From: Laura Gibbons <Laura.Gibbons@arun.gov.uk>
Sent: 01 June 2021 14:00
To: Planning.Responses <Planning.Responses@arun.gov.uk>
Cc: Anita Gardner <Anita.Gardner@arun.gov.uk>
Subject: RE: Planning Consultation on: AB/45/21/PL

Engineers Comments Regarding Land Drainage

Application No: AB/45/21/PL
Registered: 15th April 2021
Site Address: Former Gasholder Station (land opposite Arundel Cemetry) Ford Road Arundel
Grid Reference: 501308 106749
Description of Works: The planning application is for remediation works to mitigate potential liabilities associated with ground conditions resulting from the site's historic use as a gasworks. This site is in CIL Zone 1 (Zero Rated) as other development.

D1820/5045/A4

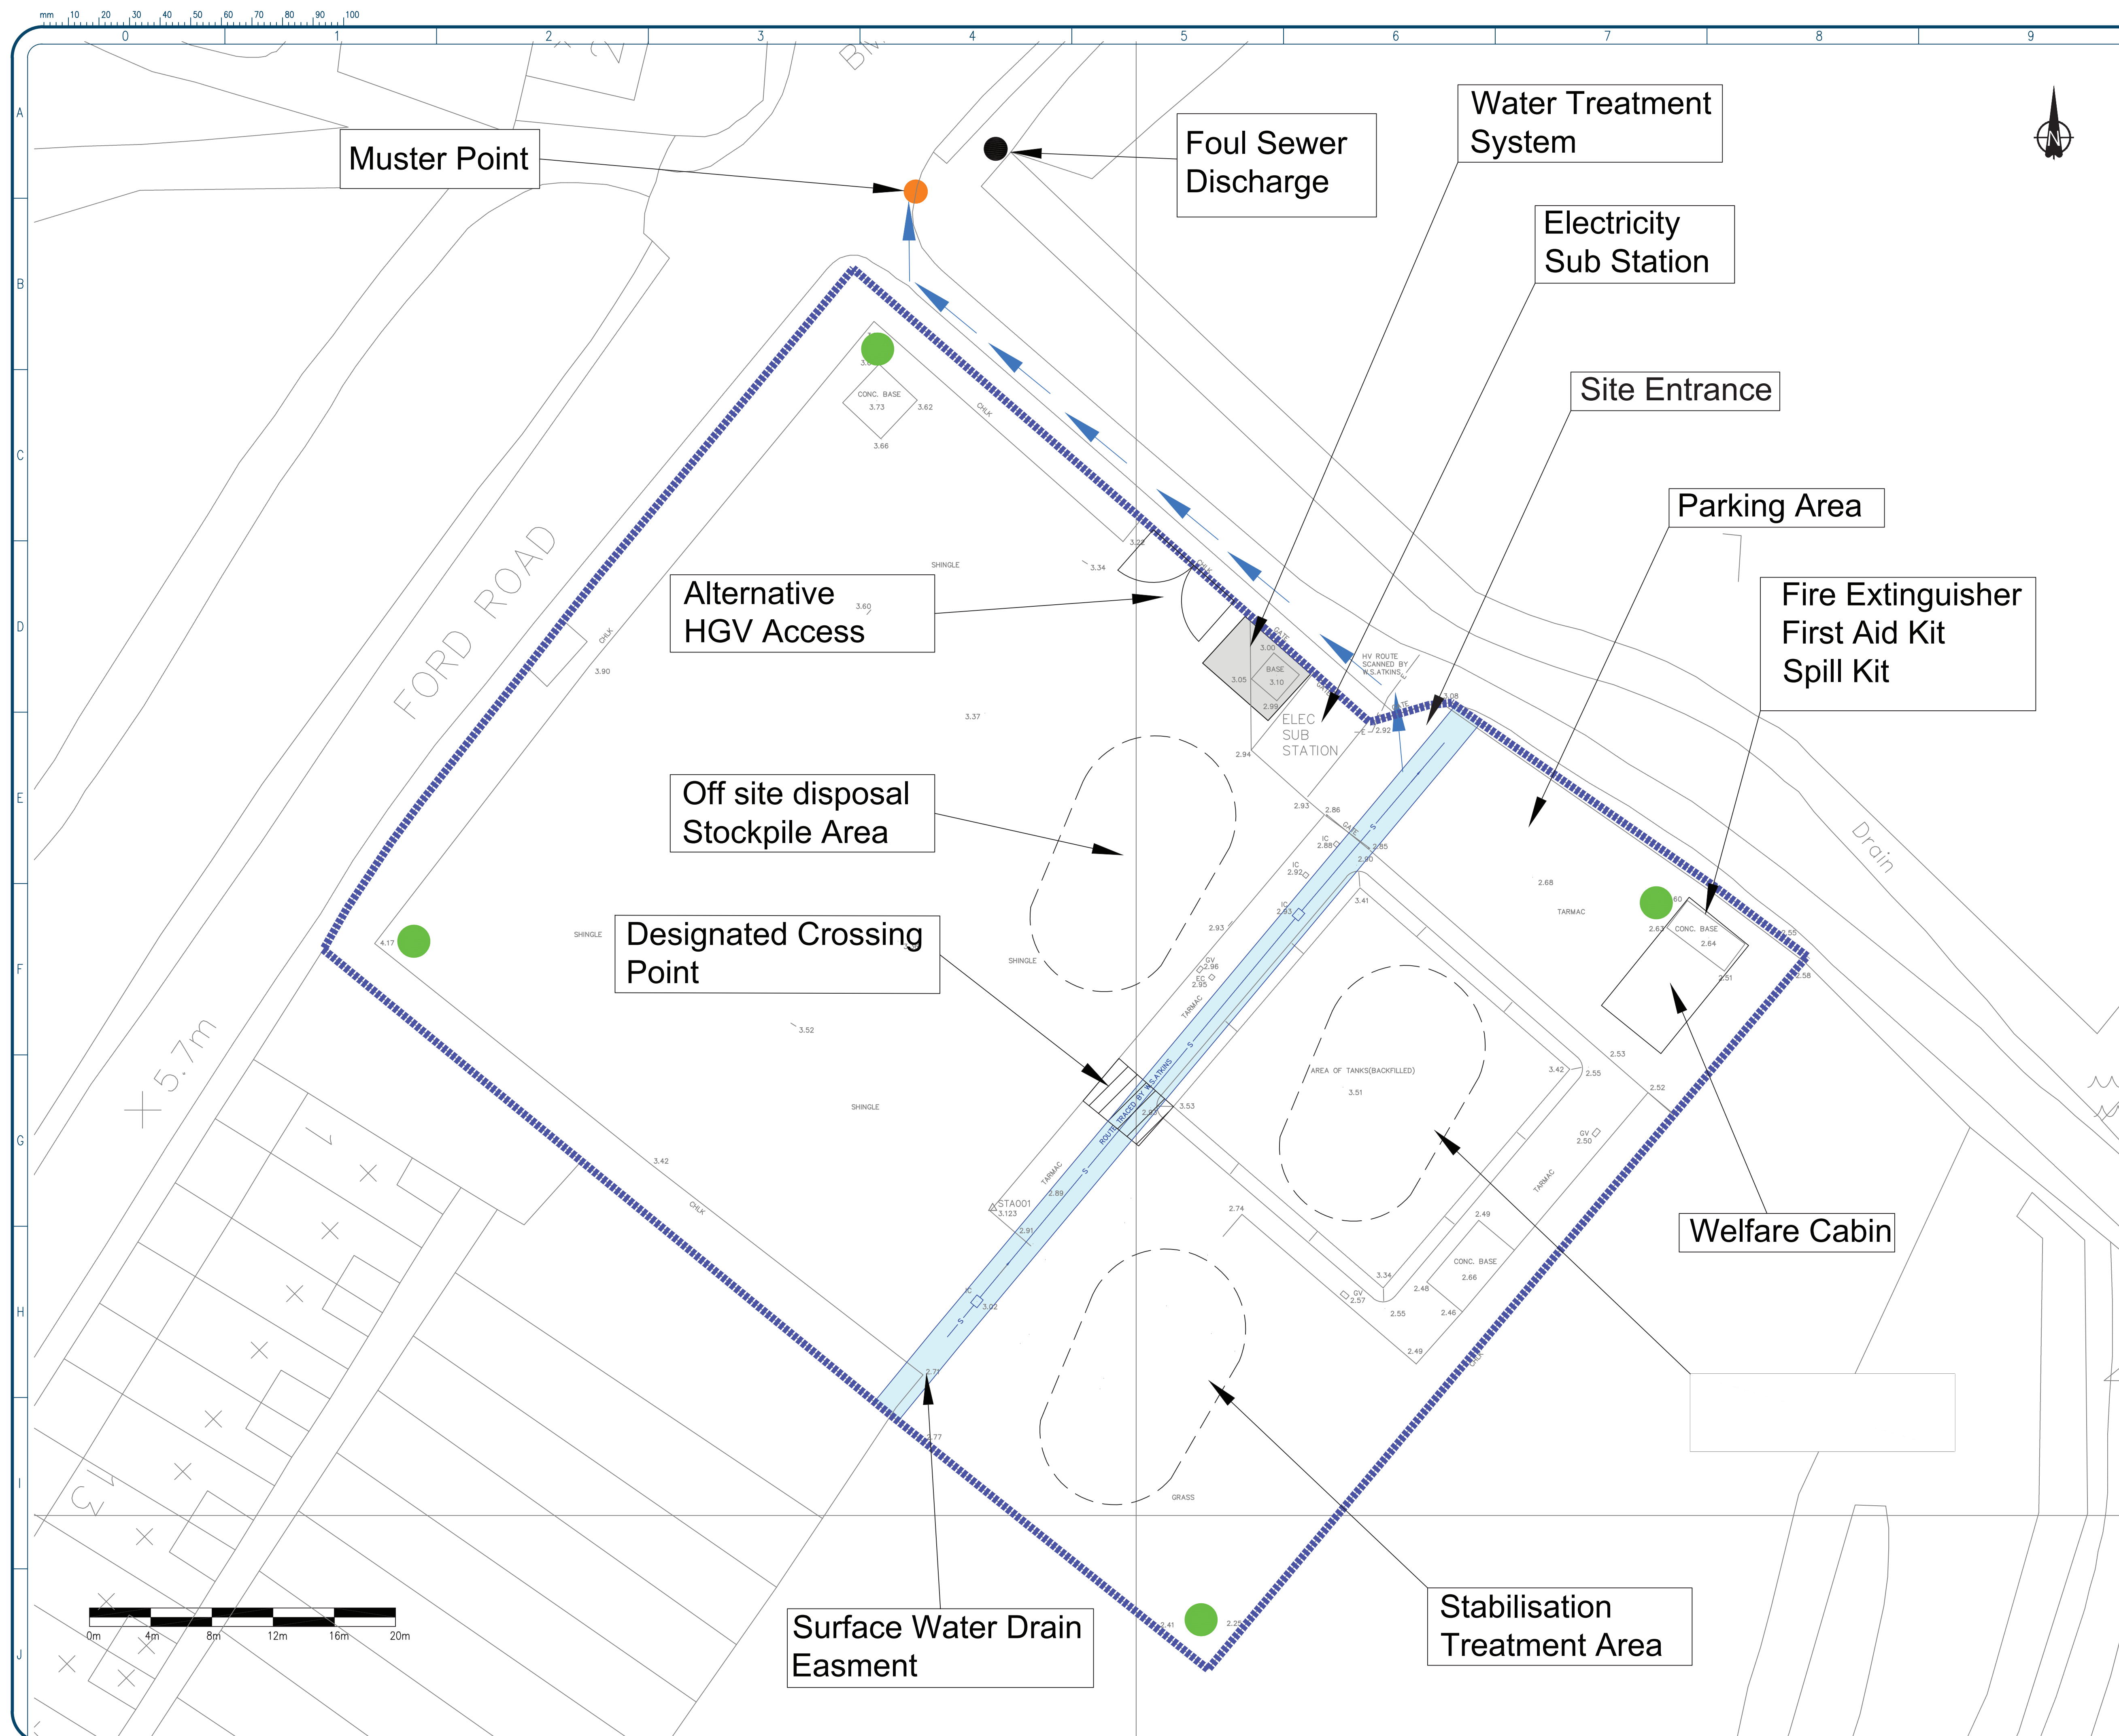
Our records indicate that there is a culverted ordinary watercourse within this site. The plans supplied appear to detail this as a surface water main. We note that it is proposed to provide a 1m easement to this culvert during works. The culverted ordinary watercourse is part of the Arun IDB which is currently within the Environment Agencies remit. We would recommend that the applicant speaks with the Environment Agency to ensure that they are happy with proposals to protect the culverted watercourse during works.
